PLANNING APPLICATION CONSULTATION RESPONSE

Application Number:	3/2024/0395
Proposal:	Approval of details reserved by conditions 5 (cycle storage), 12 (SW drainage), 13 (water mains), 14 (hard and soft landscaping), 17 (construction SW management plan) and 18 (operation and maintenance manual) from planning permission 3/2021/1134.
Location:	Land east of Chipping Lane Longridge

Lead Local Flood Authority Position

Title: Developable Areas Plan

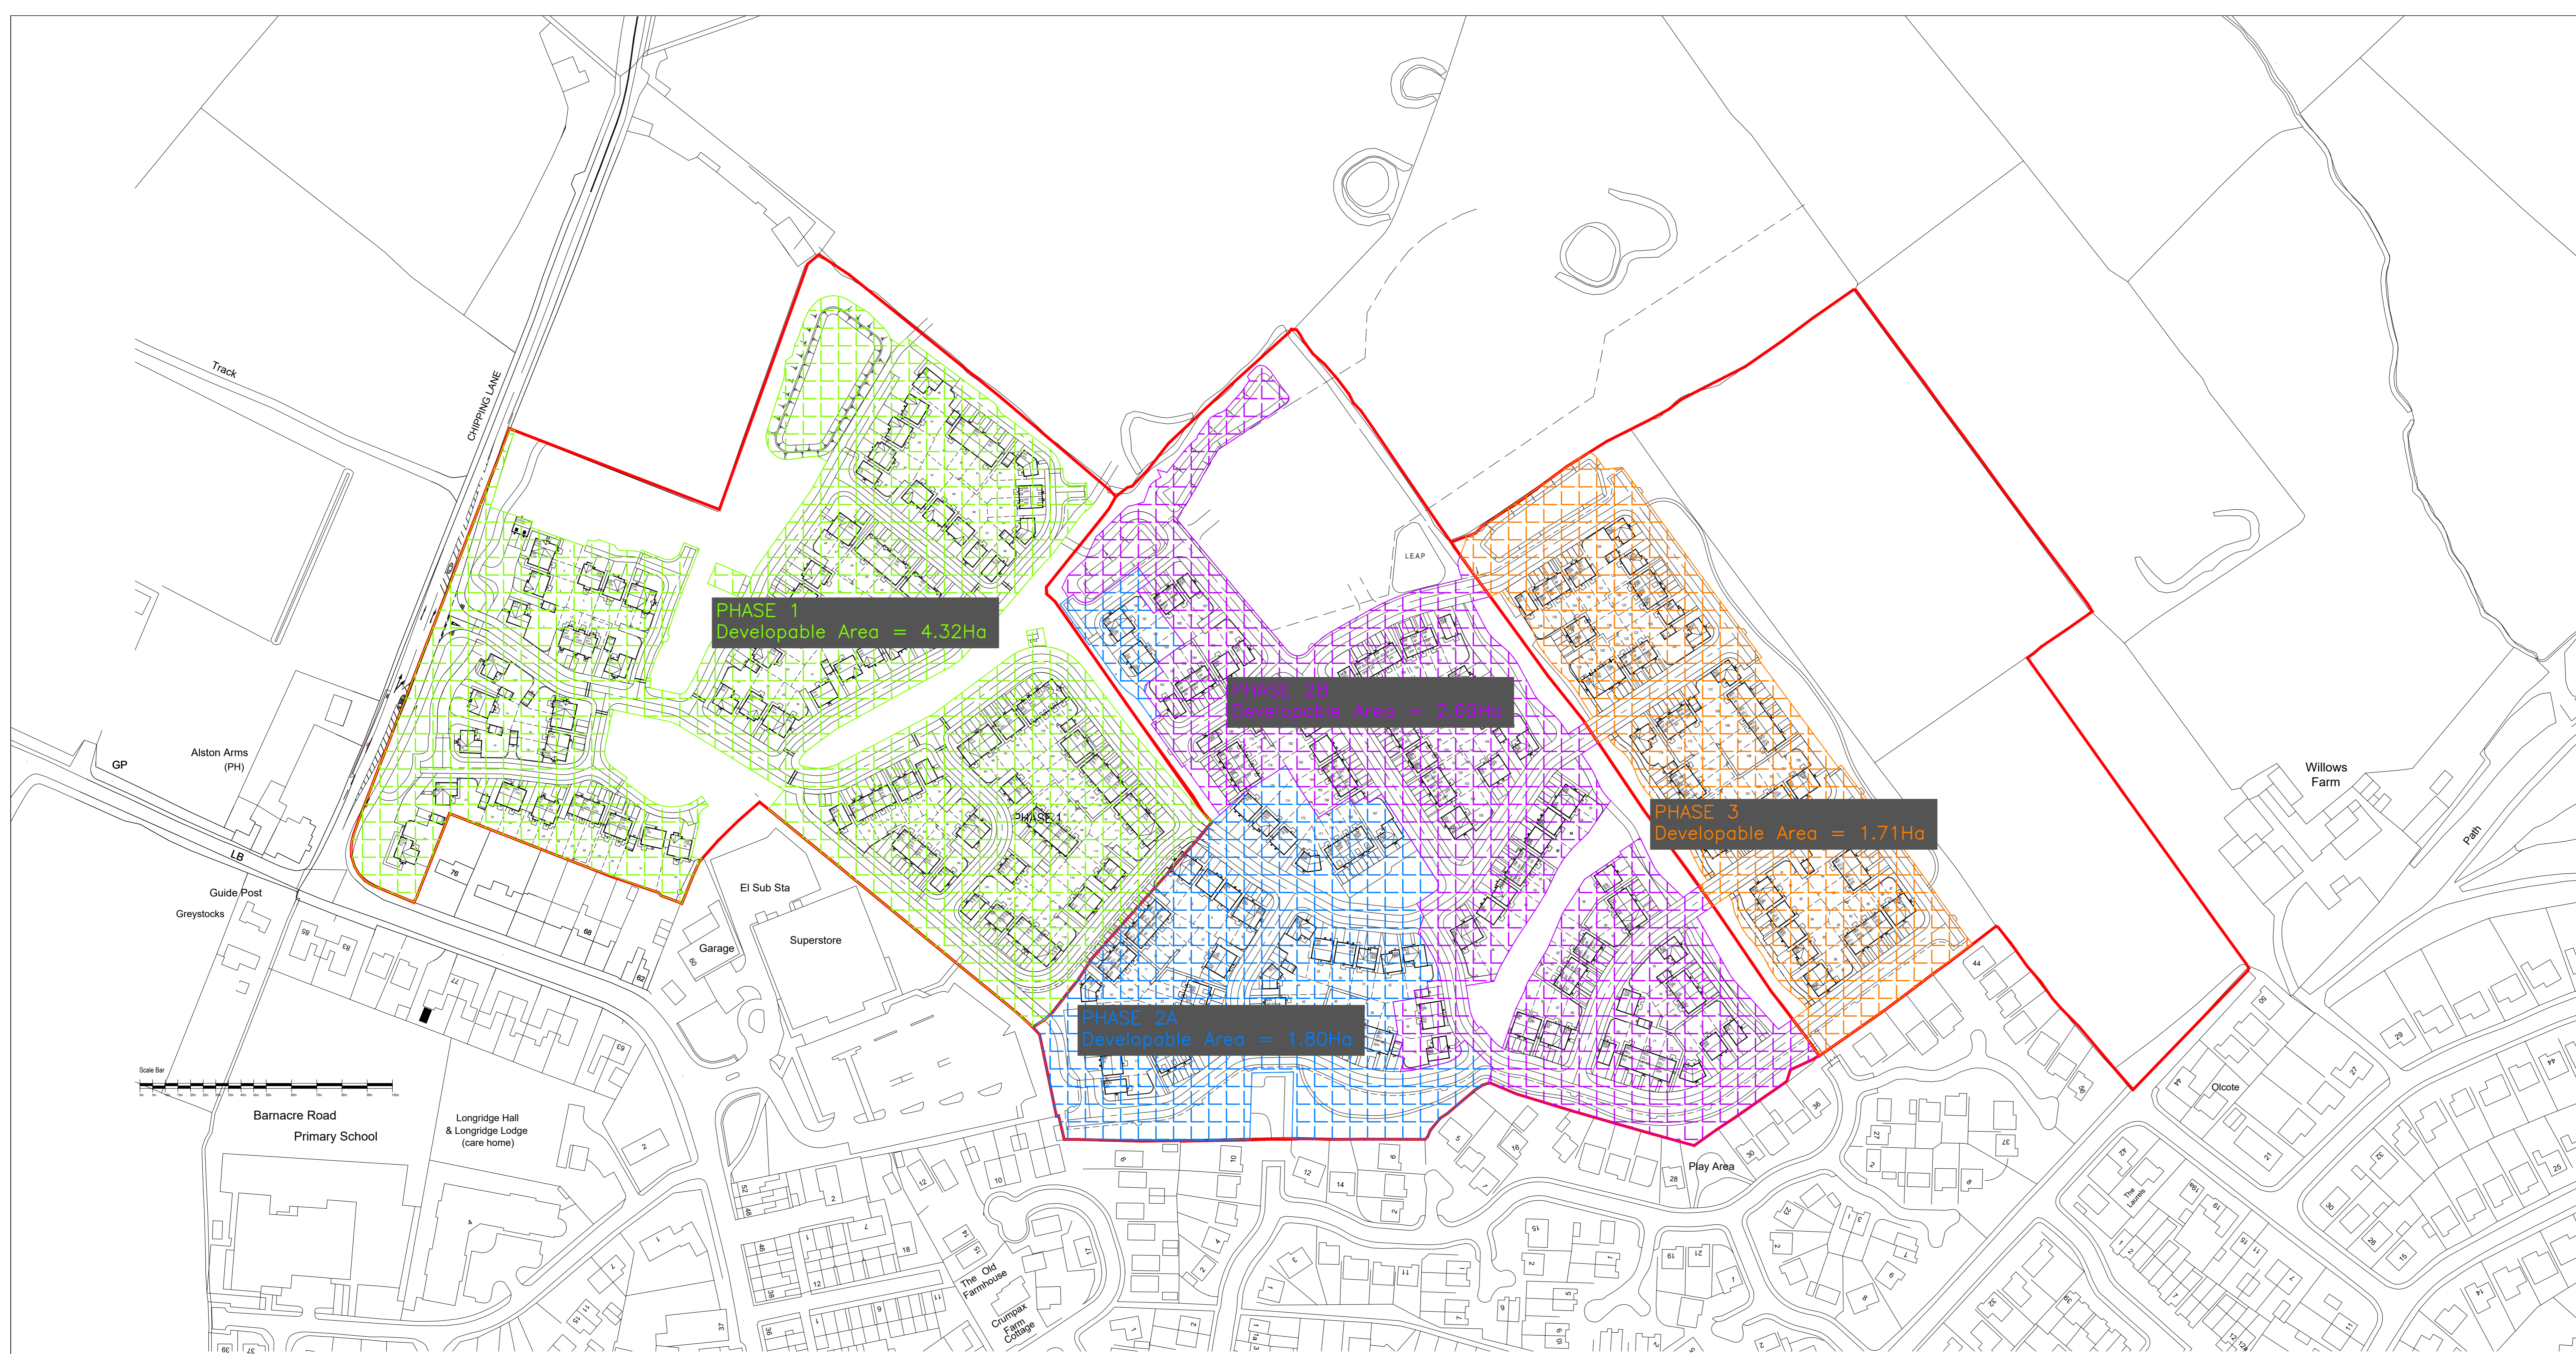
Within the applicant's drainage strategy report, specific reference is made to the proposed discharge rates for network 2 and network 3 from the development which will both serve this phase of the development. The proposed rate for network 2 are 36.6l/s and for network 3 are 23.3l/s, which is based on 13.6l/s/ha, the applicant has failed to demonstrate within the drainage layout that these are the proposed discharge rates that will leaving the final outfall for each network from their respective flow control manholes, S324 for network 2 and S414 for network 3.

Furthermore, the drainage calculations provided fail to demonstrate parameters which outline that flow controls, restricting the rate of discharge for these two networks are to be utilised, which therefore also demonstrates within the calculations that discharge rates leaving each network are in excess of the proposed Qbar rates for the 1in100 year event. The applicant must demonstrate that the final discharge rate for each network does not exceed the proposed rates of 36.6l/s for network 2 and 23.3l/s for network 3 for each event, up to an including the 1in100 year + climate change.

Description
Surface Water Management Plan - Phase 2 & 3

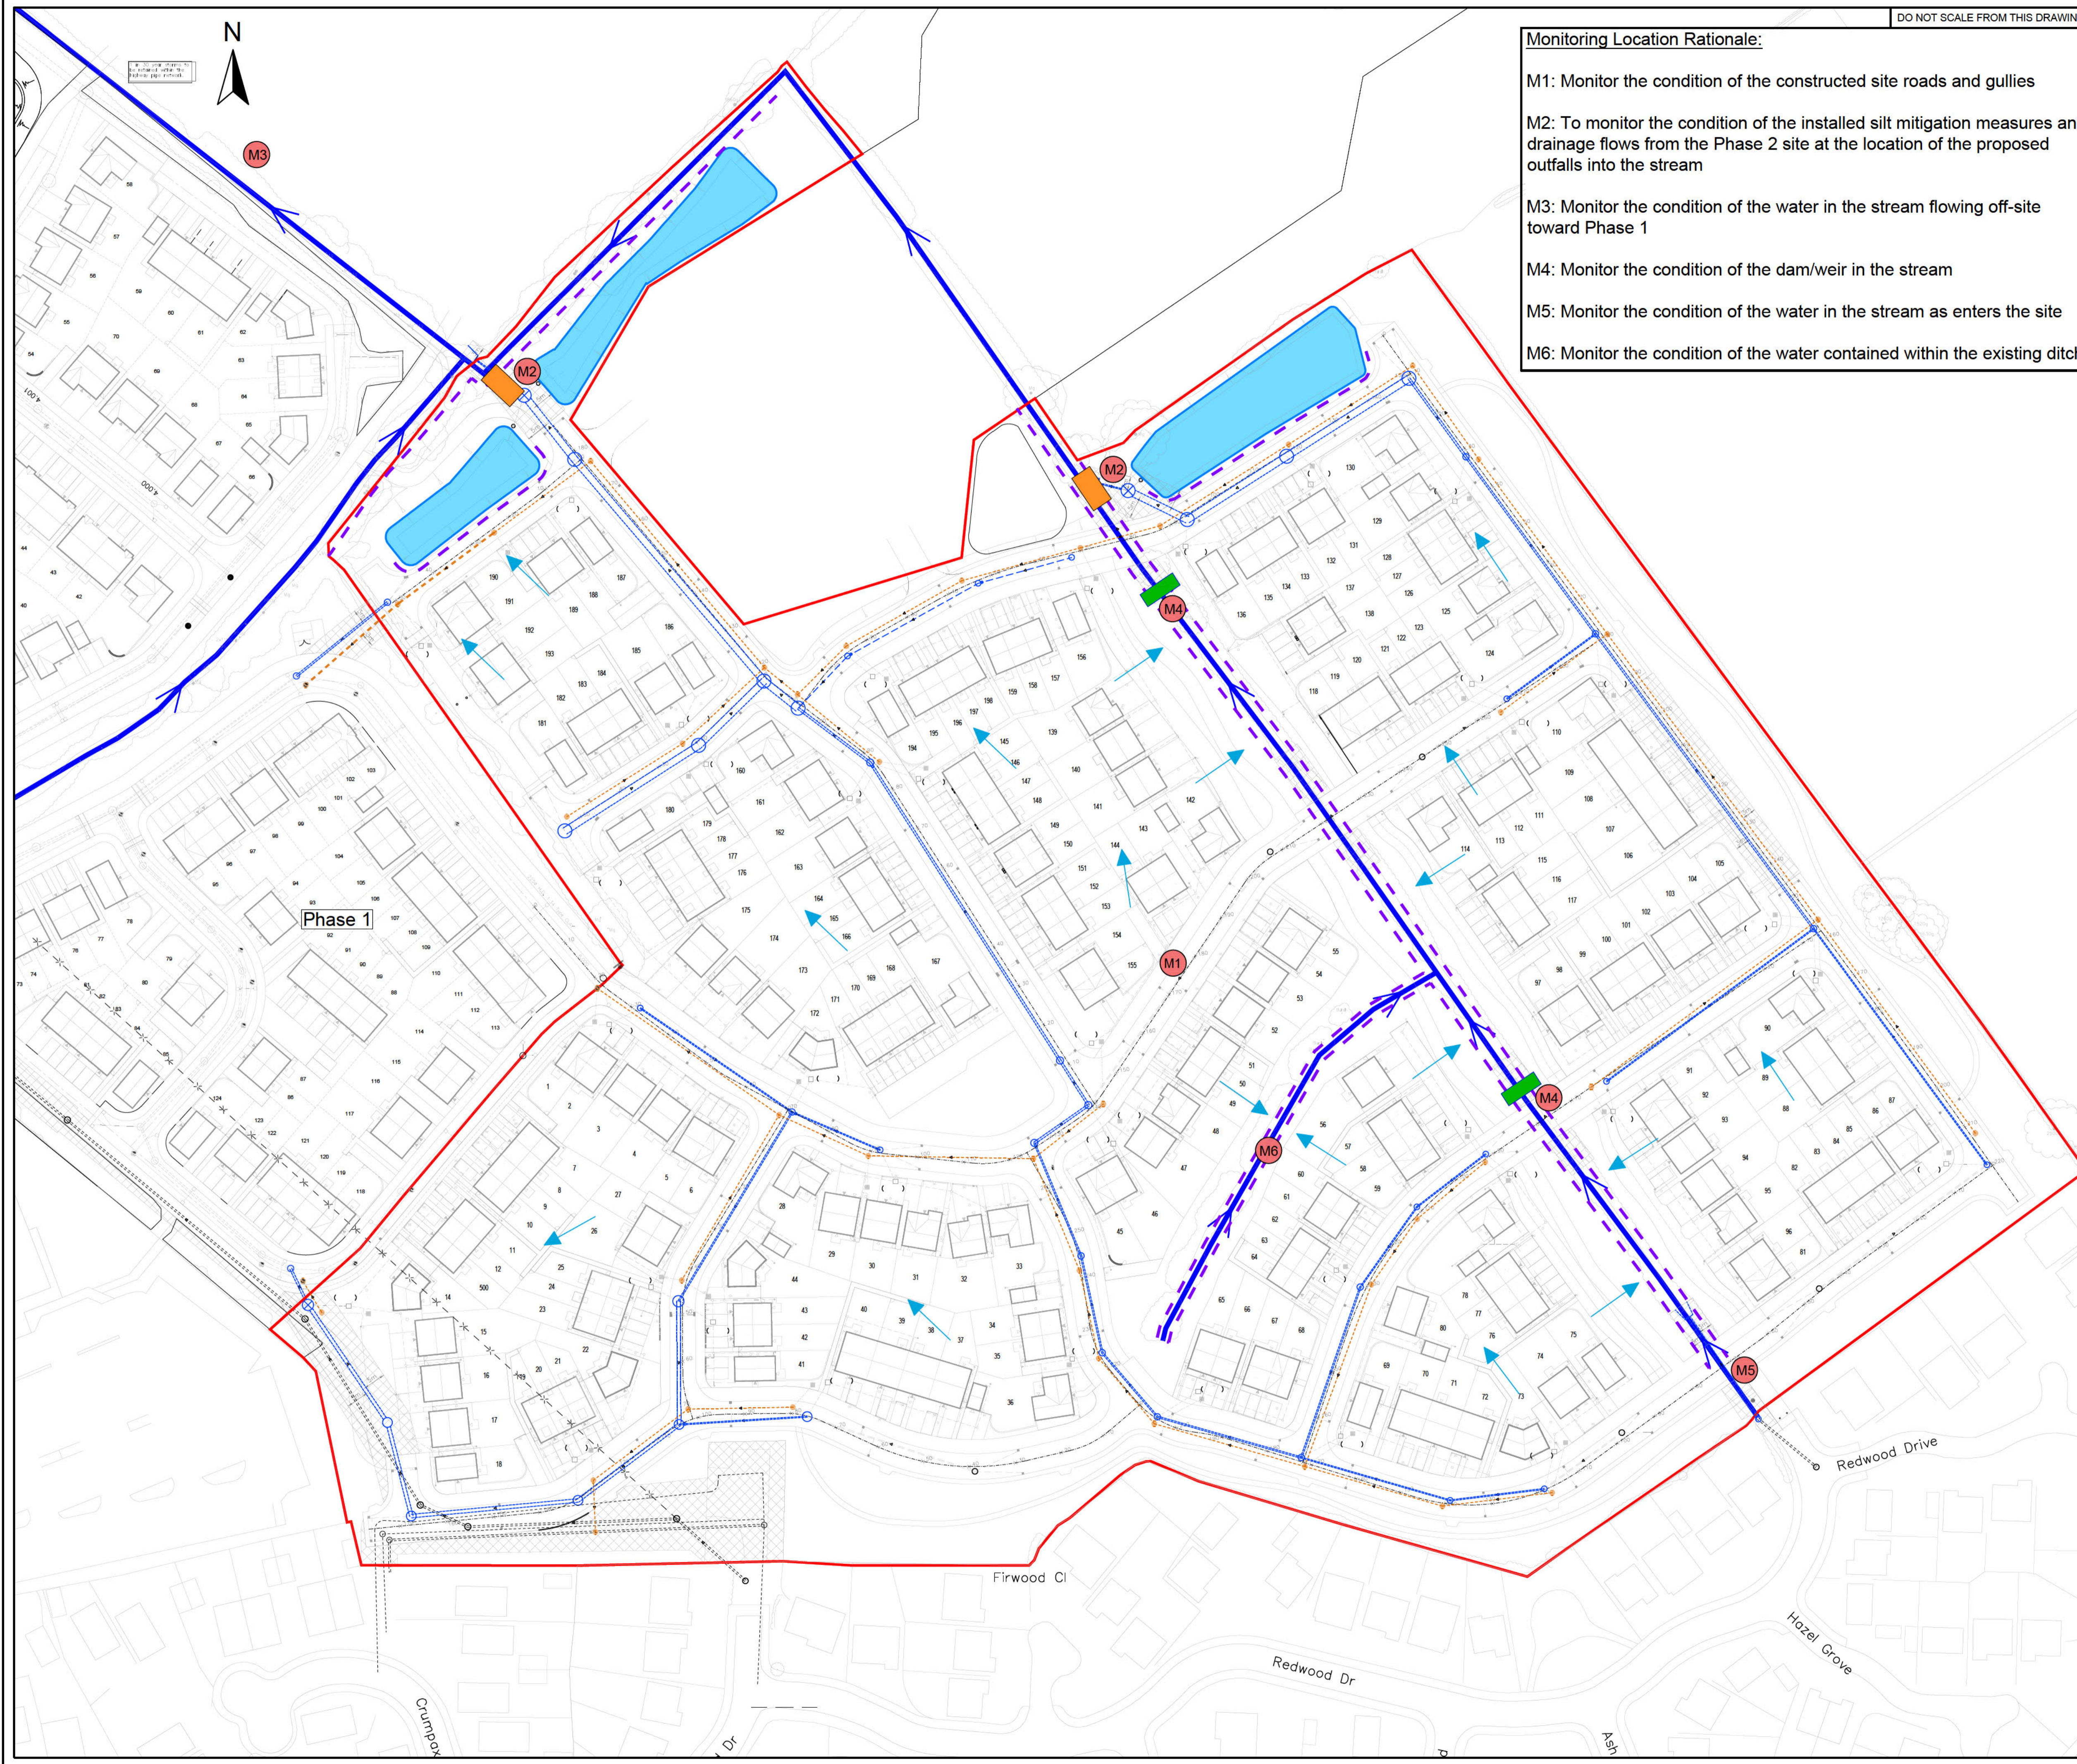
- The applicant has failed to provide sufficient evidence of flood water exceedance routes.

Although the applicant has demonstrated exceedance routes in relation to the areas outside the development and the watercourses, the applicant will need to demonstrate the flood water exceedance routes in relation to the proposed drainage system and how this manifests in conjunction with the proposed road levels, finished floor levels, cover levels and invert levels and appropriate drainage calculations.
